6 November 2013

***Modification Request for the University of Sydney Abercrombie Precinct
Redevelopment: Application Number: MP07_0158 MOD 3***

I am a resident of Darlington and I am writing to you to make the following objections in relation to the above development modification request by the University of Sydney because the modifications would have an unacceptable adverse impact on the amenity of nearby residents.

Ground Floor Plan
1:200@A1
11.10.13
4001_DA02-D

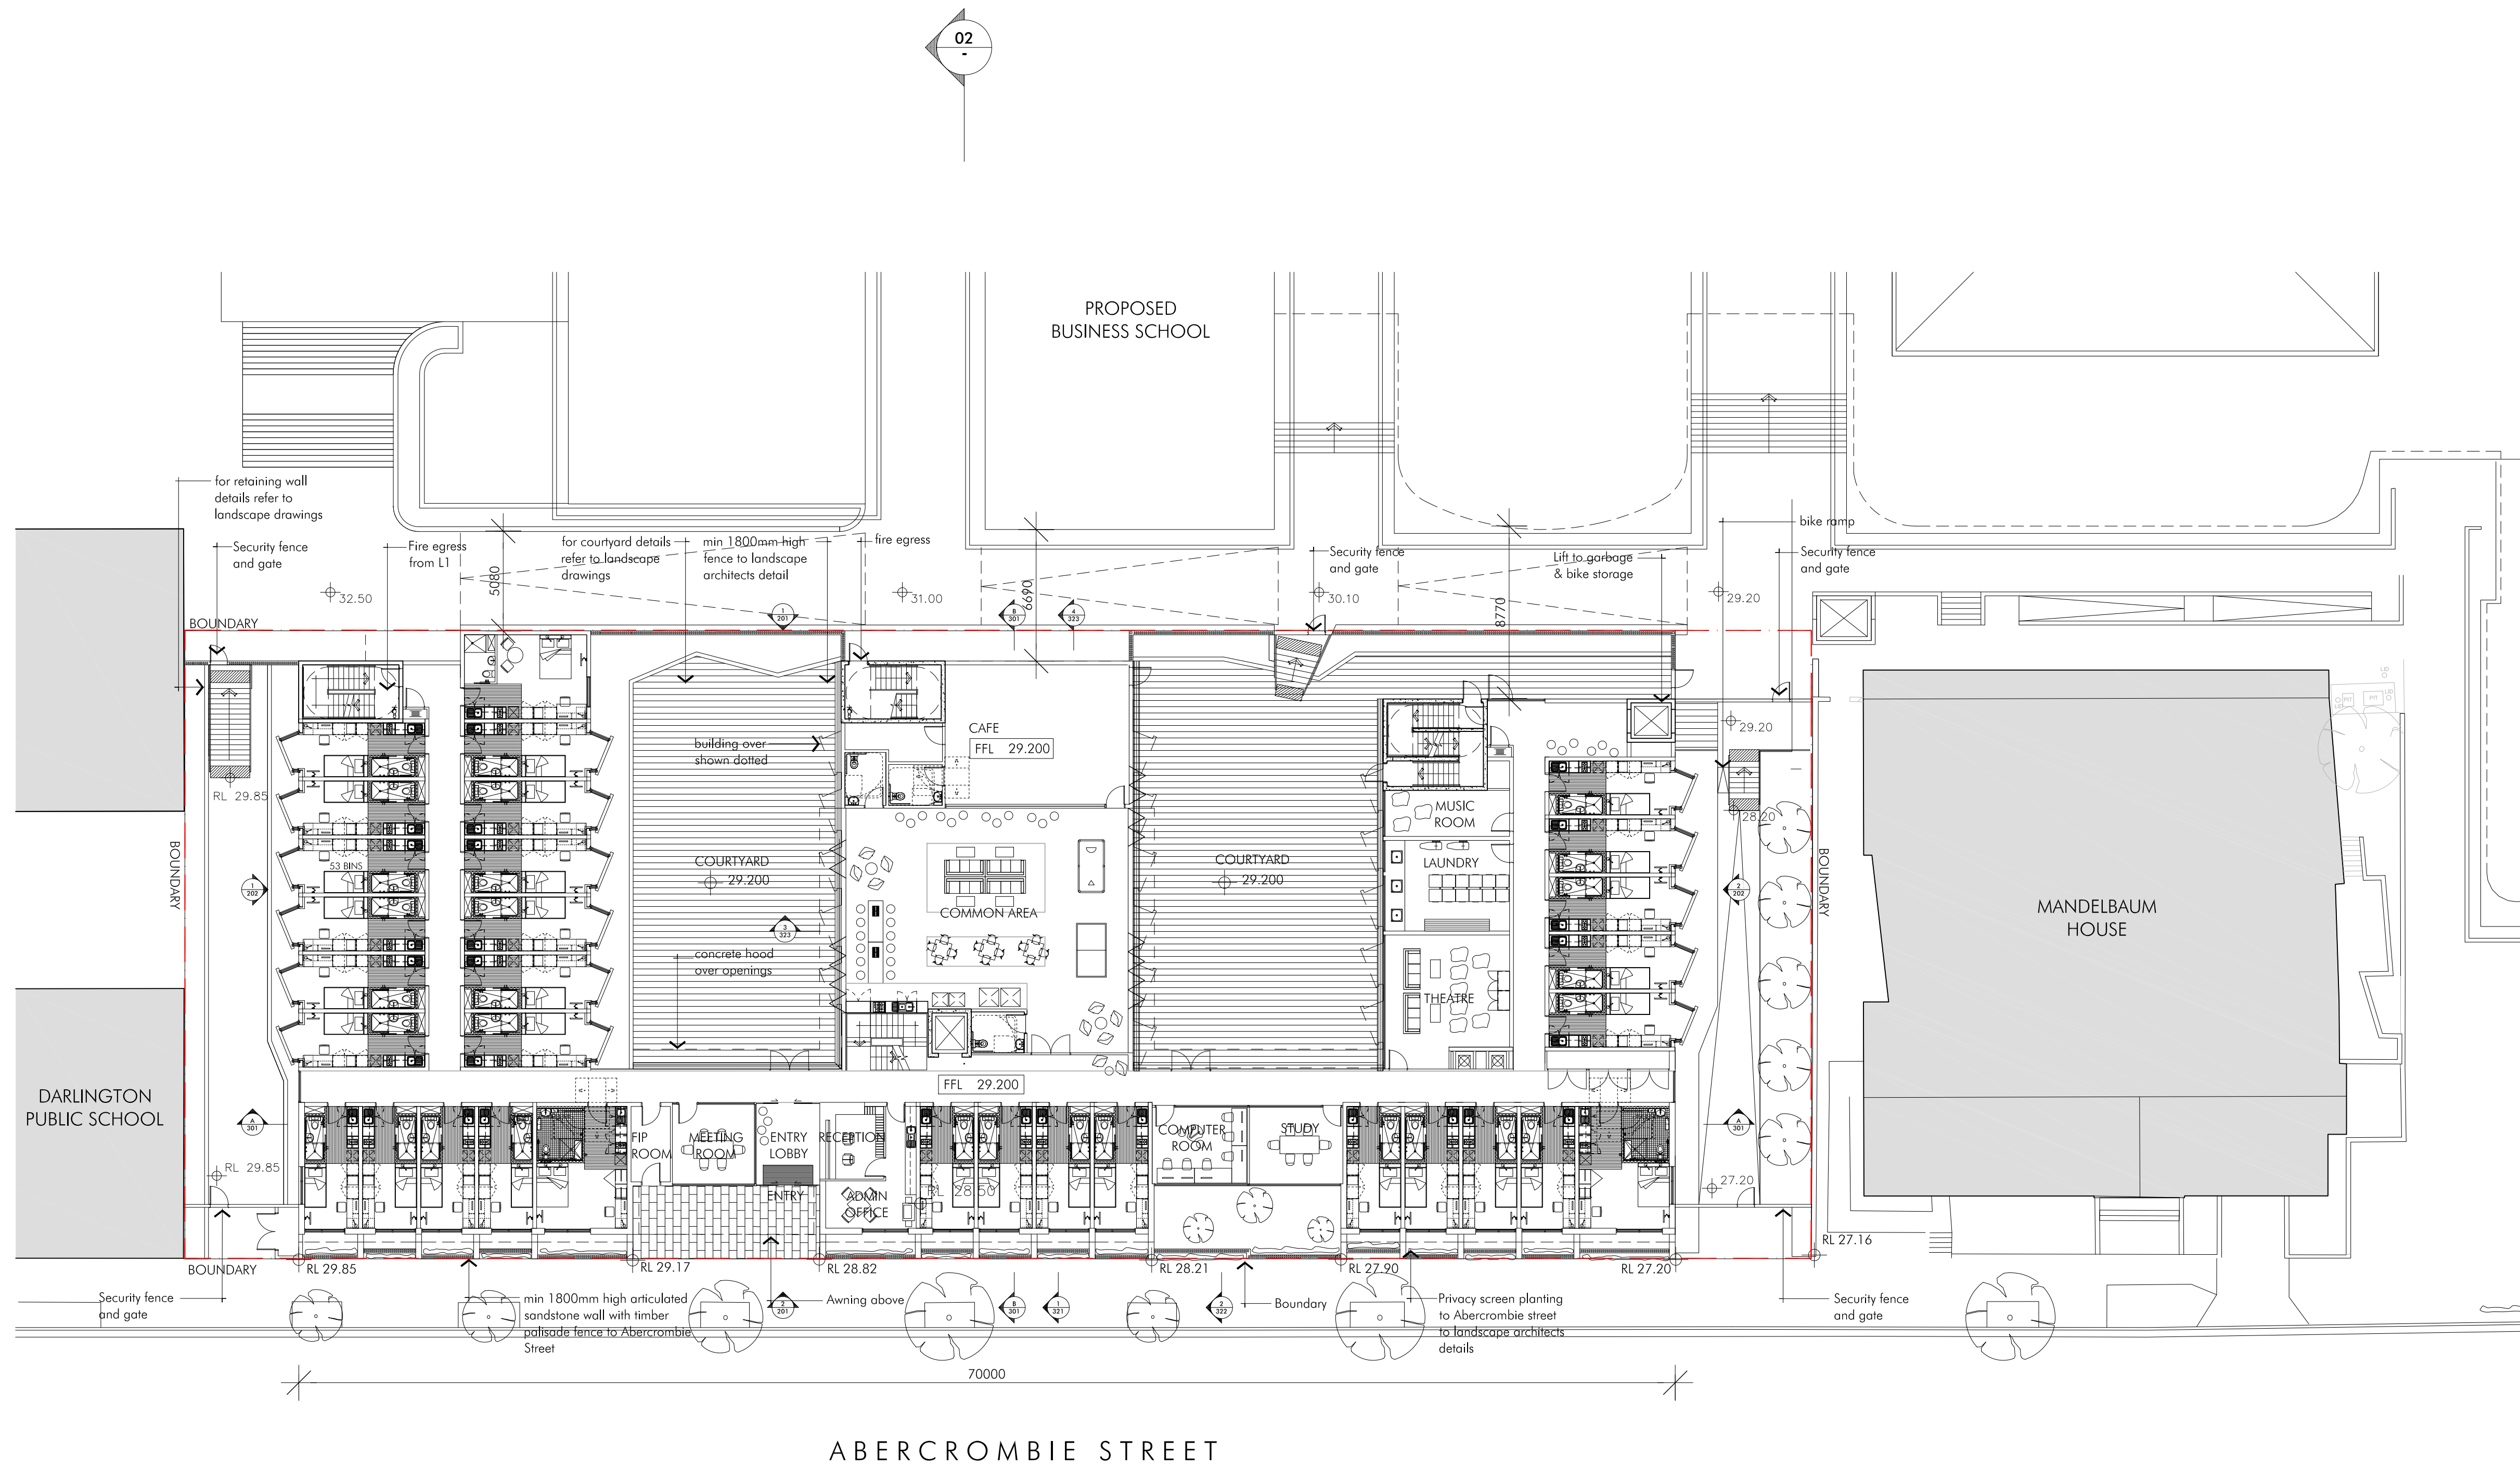
- The front of the Student Accommodation building should be built 2 metres back from the Abercrombie Street boundary. It should be set back from this boundary so that it is in line with Mandelbaum House as it was originally planned and presented to the community. The footprint of the buildings currently on the site, The Shepherd Centre and Boundary Lane Children's Centre, were built approximately 2 metres back from the Abercrombie Street boundary and align with Mandelbaum house. Therefore, the front footprint of the proposed Student Accommodation building should be the same as those buildings occupying the site at present and not be built up to the Abercrombie street boundary.

- The facade of the proposed Student Accommodation building does not reflect the heritage appearance of the Victorian terraces on Abercrombie Street as Mandelbaum House does. Therefore, it should be set back to allow for extensive vegetation and trees to be planted in front of the building on Abercrombie Street to help preserve the heritage streetscape and improve both the aesthetics and the environment of the street.
